Re: Sunroom Addition - Addendum
479 D.L. Phillips Lane
Broadway, North Carolina

OTG Consulting, PLLC (OTG) was requested to evaluate the design change for the sunroom addition. We understand that an original structural design was performed by Line on Design, dated April 14, 2023. OTG was requested to review the provided value-engineered design performed by you. OTG previously provided a letter detailing the design changes (OTG report dated September 22, 2024).

1
S-5

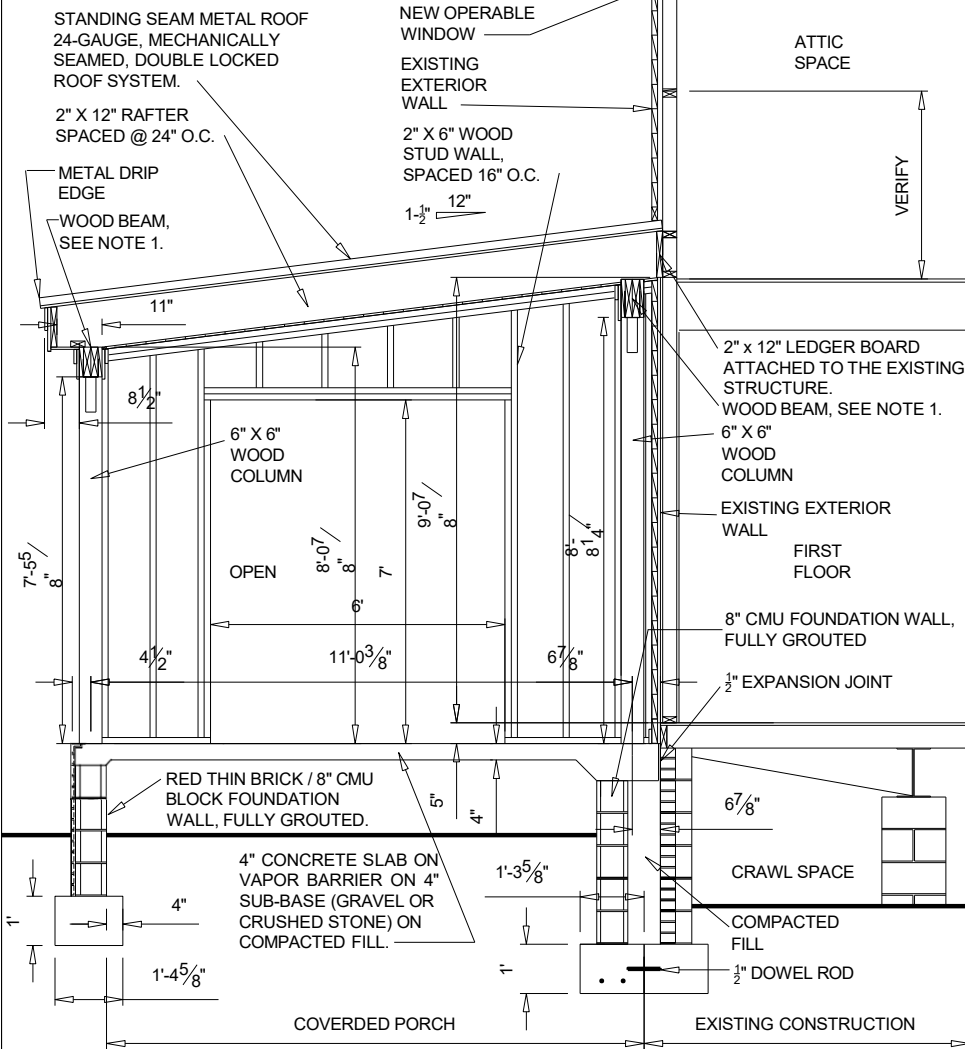
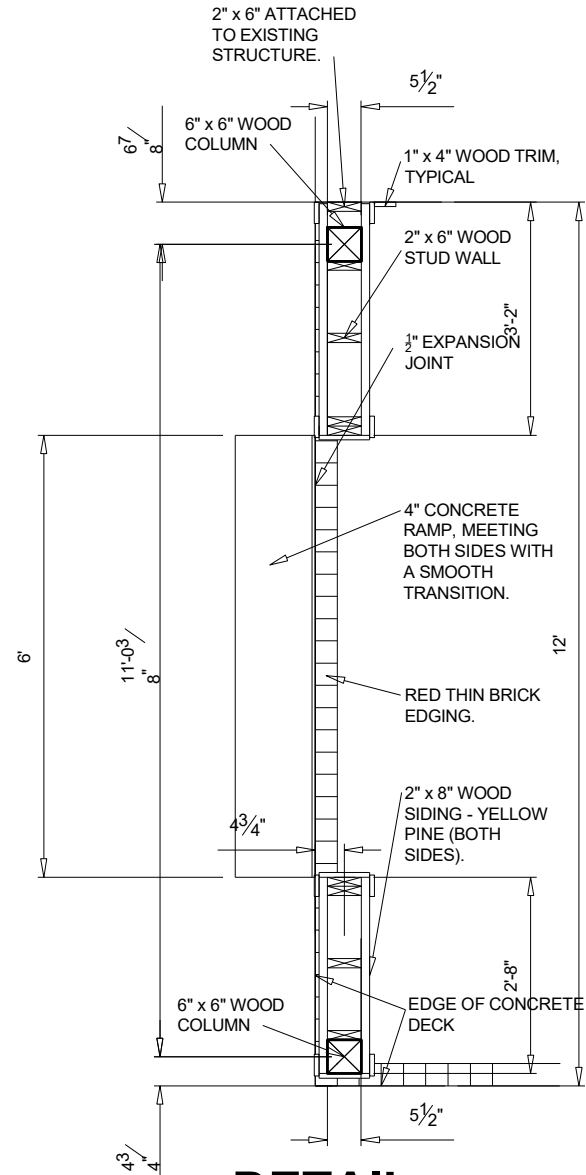
Additionally, at the covered porch the plans originally called for the LVL fastened to the 6-inch by 6-inch posts with Simpson Strong Tie Post Caps at each column (detail 1/S5). In lieu of the Simpson Strong Tie Post Caps, the plan is to use (2) Timber Lock lag screws through the post into the LVL. The post is notched to allow for the LVL to sit on the column. Based on the review and analysis of the loads on the fasteners, this is an acceptable substitution and will support the applied loads.
